Application No: BR/112/20/PL
Site Address: 14a Canada Grove Bognor Regis PO21 1DN
Description of works: Single storey rear extension

Thank you for your internet representation made on 18th June 2020 which has been recorded as an objection with the comments as follows:

Proposed

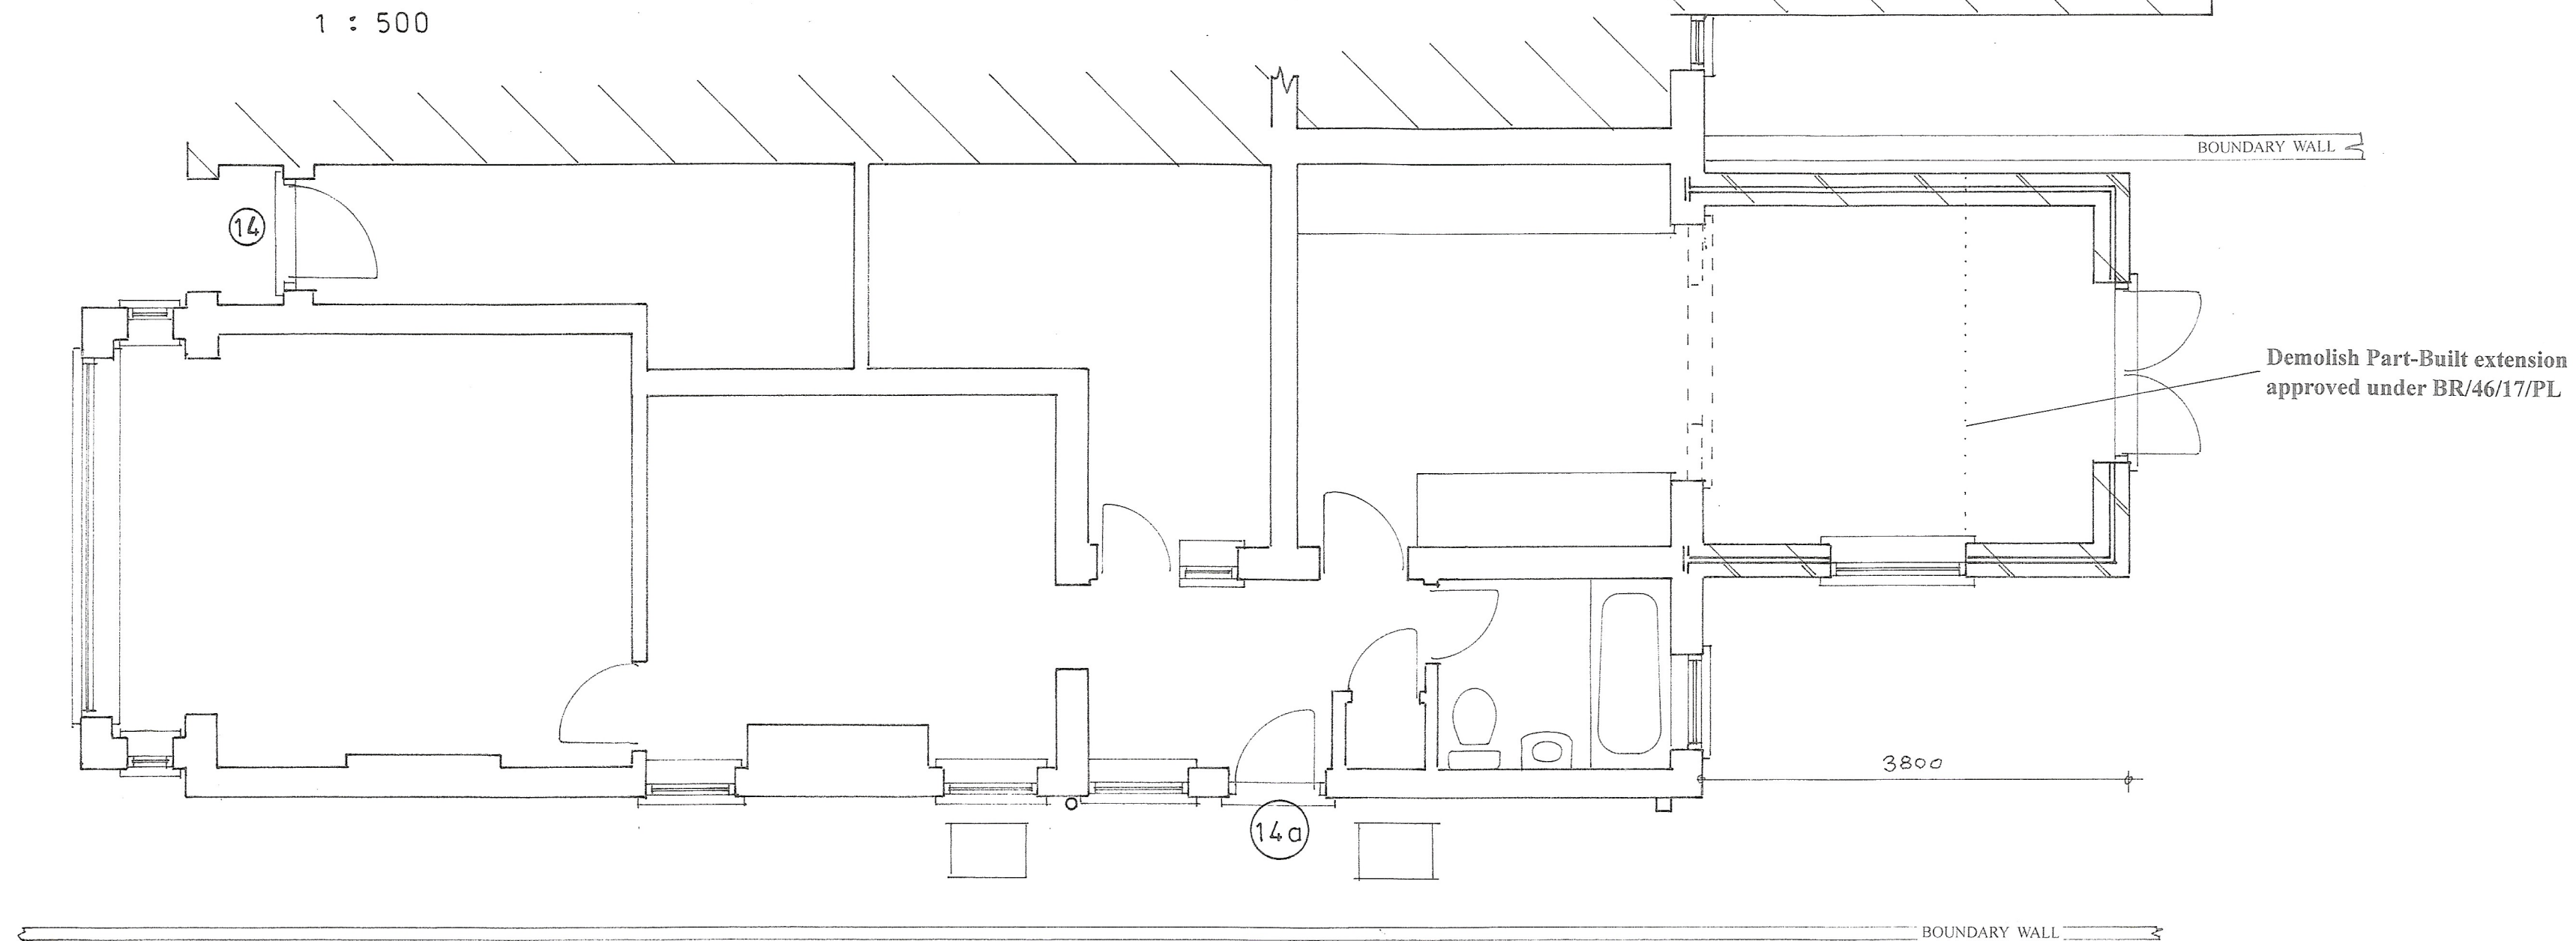
I live in the neighbouring property and previously objected to the planning application made under ref BR/46/17/PL on the basis that I was concerned that once the works were completed the 2.3m projection with high eaves on the proposed pitched roof, the light entering my property would be severely restricted. The works were never completed and now has been demolished. To be replaced with a 3.8m projection extension- again adjacent to our boundary.

The extension to the rear of the property was built away from the boundary line which meant that the extension was not over bearing on 14A Canada Grove. The conversion of my property also left a window on the original back wall which is now the only window serving my bedroom. If a 3.8m extension is built at number 14A, adjacent to the boundary line, that building will be overbearing on my property and will significantly impeded upon the light entering my bedroom.
